ASSESSMENT REPORT

Section 75W Modification Tweed Ultima, Modification 6 (DA-456-10-2003 MOD 6)

Figure 1: HRV Access into On-street Servicing Bay

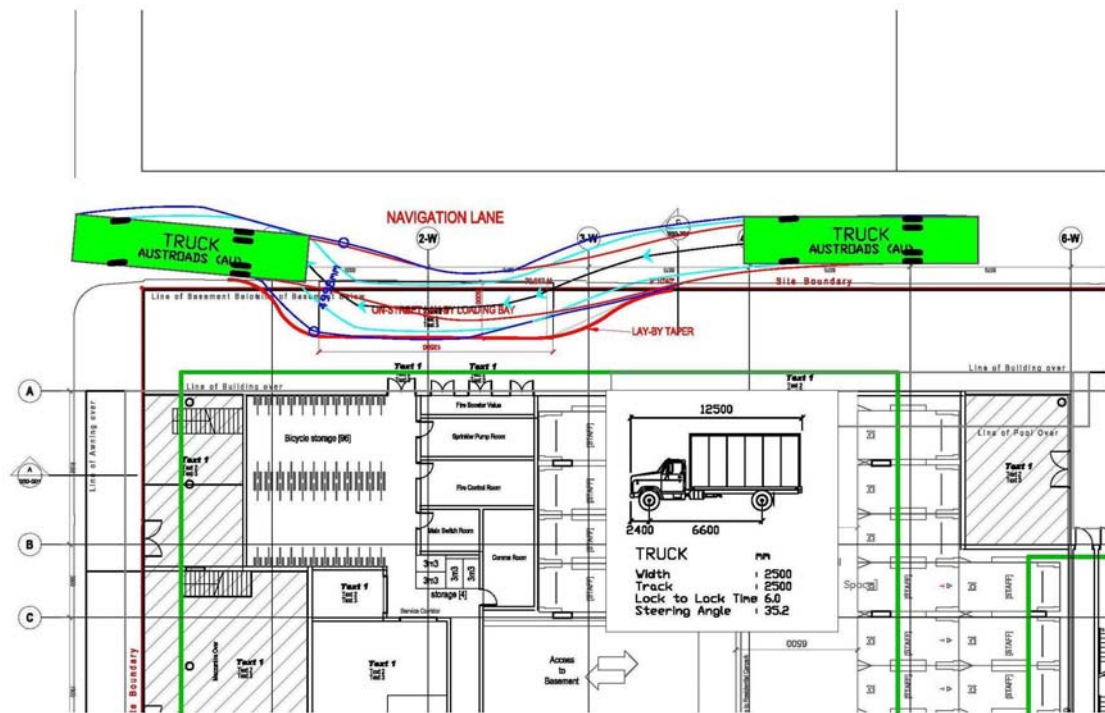
The department originally supported this 'reverse in' arrangement because of low traffic volumes in Navigation Lane. However, potential conflict now arises because of the greater number of vehicle movements along Navigation Lane, which may bank-up behind parked or reversing service vehicles.

The proponent's RTS amended the eastern ground level to include an indented service bay on the site adjoining Navigation Lane. The design of the service bay (**Figure 15**) provides:

- a 12.5m length to allow access for a garbage collection vehicle;
- road tapering for efficient service vehicle manoeuvring; and
- a 3m width to store a service vehicle clear of Navigation Lane.

The department considers a service bay is required to ensure adequate traffic flow, and reduce the incidence of blocked traffic in Navigation Lane. Council supports the proposed service bay.
